Application Ref:	3/2021/0098	 Ribbles Valley Borough Council www.ribblesvalley.gov.uk
Date Inspected:	Pre-Application	
Officer:	SK	
DELEGATED ITEM FILE REPORT:		REFUSAL

Development Description:	Proposed Conversion of a barn to a residential dwelling and associated works.
Site Address/Location:	Lea Barn, Four Acres Lane, Preston.

Proposed & Existing Site Plan
& Location Plan

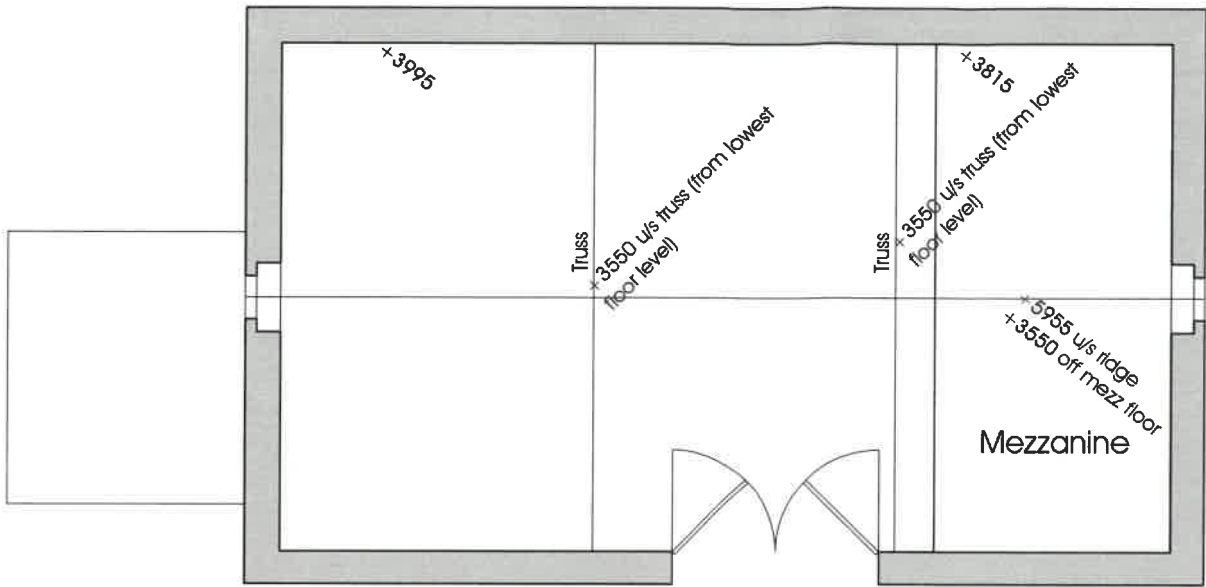
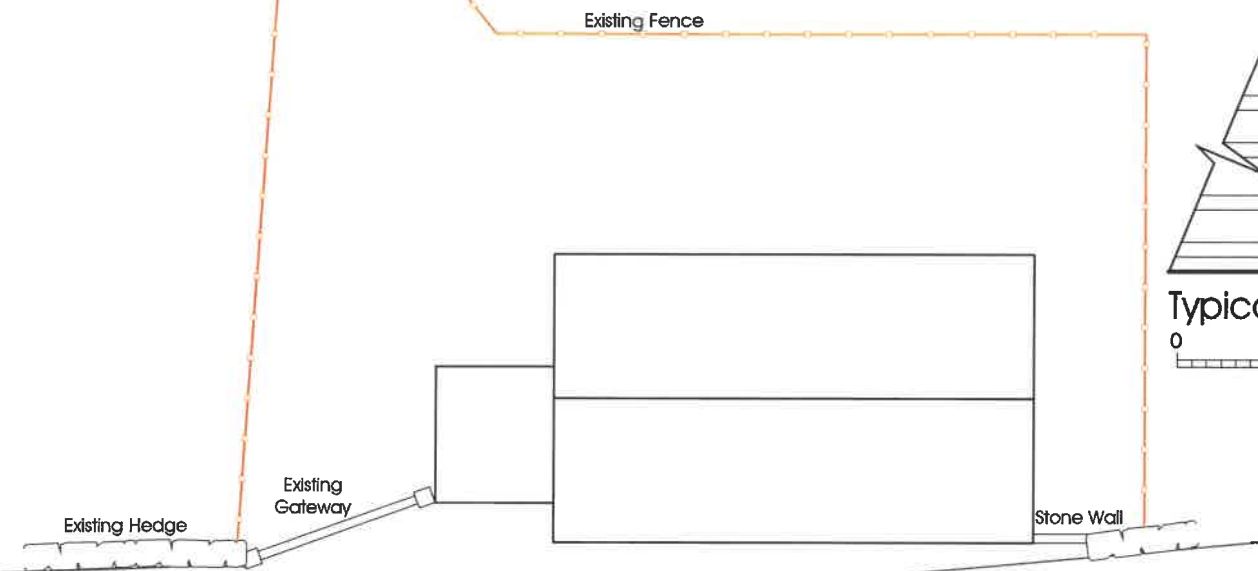
The submitted details do not propose the introduction of any additional openings to accommodate windows/doors with the envelope of the building remaining relatively intact save that for the introduction of three conservation-style rooflights on the south facing roof-slope. The submitted details also propose the creation of a dedicated residential curtilage to incorporate a driveway, lawn and patio area including dedicated parking provision. It is proposed that the curtilage will be delineated by 1.2m high post and rail fencing.

However, the extent of the proposed residential curtilage, in concert with the proposed dedicated parking provision, boundary treatments and likely visual impact of associated domestic paraphernalia such as sheds, washing lines, children's play equipment and fence lines would result in the introduction of a form of development of an overtly domestic and suburban in appearance which fails to reflect local distinctiveness, particularly by virtue of its roadside location and as such is likely to result in significant detriment of the character, appearance and visual amenities of the area and the Forest of Bowland AONB landscape.

| 03 | The proposal, by virtue of the extent and scale of proposed residential curtilage, driveway/parking area and the likely visual impact of associated domestic paraphernalia such as sheds, washing lines, children's play equipment and fence lines would result in the introduction of an incongruous form of residential development which is overtly domestic and suburban in appearance which fails to reflect local distinctiveness, vernacular style or acknowledge the special qualities of the area or contribute or enhance its setting, being of significant detriment of the character, appearance and visual amenities of the area and the Forest of Bowland AONB contrary to Key Statement EN2 and Policies DMG1 and DMG2 of the Ribble Valley Core Strategy. |
